City of Albuquerque Stormwater Construction Site Inspection Report

ESC File No.	K09E047	Project Name:	Southern Tire Mart		
NPDES Id. No.	NMR10044B/NMR100451	Location:	8201 Daytona Rd NW		
6/5/2023	Owner	Contractor			
Operator	Southern Tire Mart, LLC	TL Wallace			
Contact name & title	Rick Yarborough				
e-mail	rick.yarborough@stmtires.com				
Contact Phone #	505-917-6442				
COA Inspector	Chancellor English	Start/End Time:	2:00 PM		
Construction Phase:	infrastructure nearly complete				
Type of Inspection:	Regular	Storm Event	Post Storm Event >0.25"	311/Complaint	Follow Up
Weather at time of inspection?	Clear	Temperature:	~	80	
Estimated date of last storm 0.25" or greater	5/22/2023

SWPPP INFORMATION SIGN

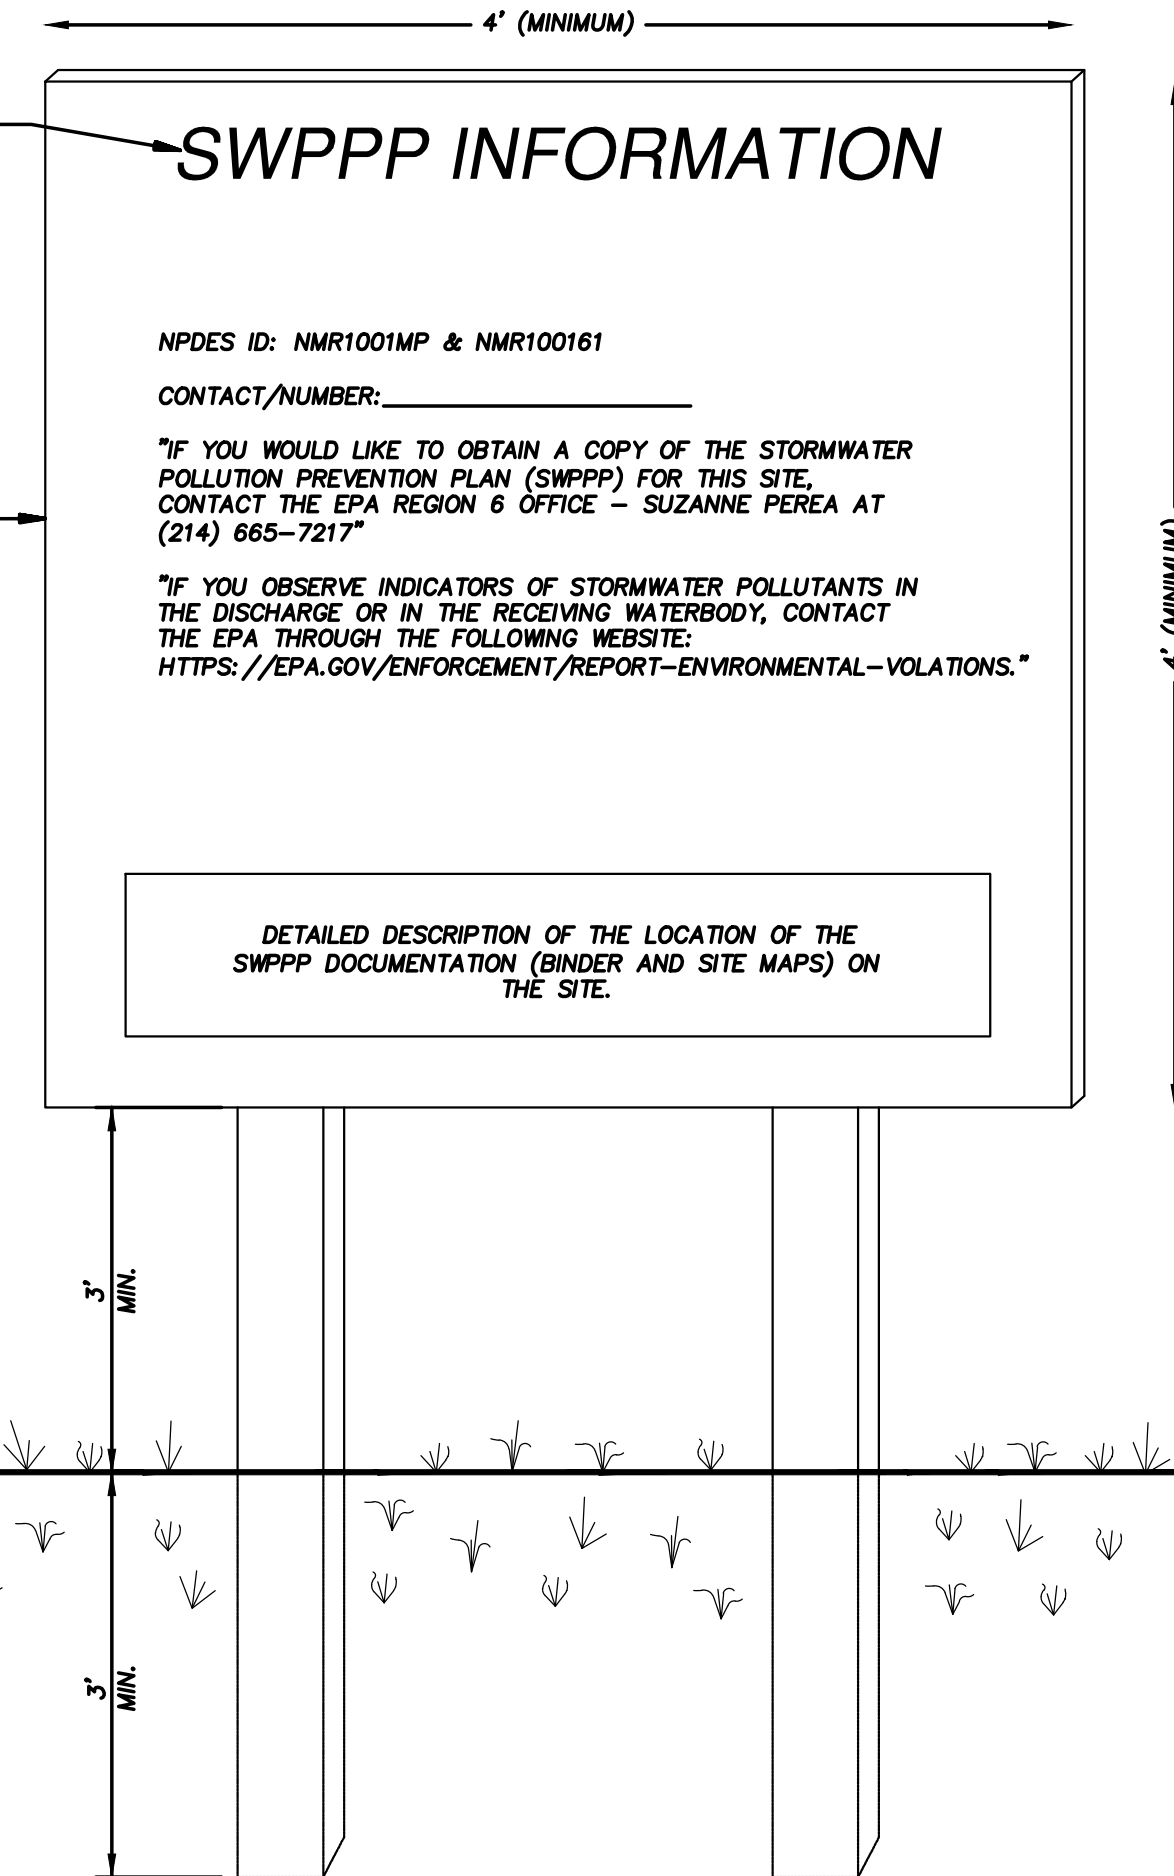
Item Number	Deficiency/ Corrective Action				
	Your NPDES Permit coverage was not posted for safe, public viewing. You must post a sign or other notice of your permit coverage at a safe, publicly accessible location in close proximity to the construction site. The notice must be located so it is visible from the public road that is nearest to the active part of the construction site, and it must use a font large enough to be readily viewed from a public right-of- way per CGP 1.5.				
	The SWPPP is missing all owner/operator signatures. As per CGP 7.2.10, the SWPPP must be signed and dated in accordance with CGP Appendix G, Part G.11				
	Your contractor's NOI is not included in the SWPPP. As per CGP 1.1.1, all operators must obtain permit coverage.				
2.1	Discharge off site? (Y/N)	no			
4	Self Inspection Reports		Latest report Date:

Notes:	Contractor's NOI is still missing from SWPPP. Permit coverage posting had incorrect NPDES IDs. The contractor held the SWPPP in his vehicle
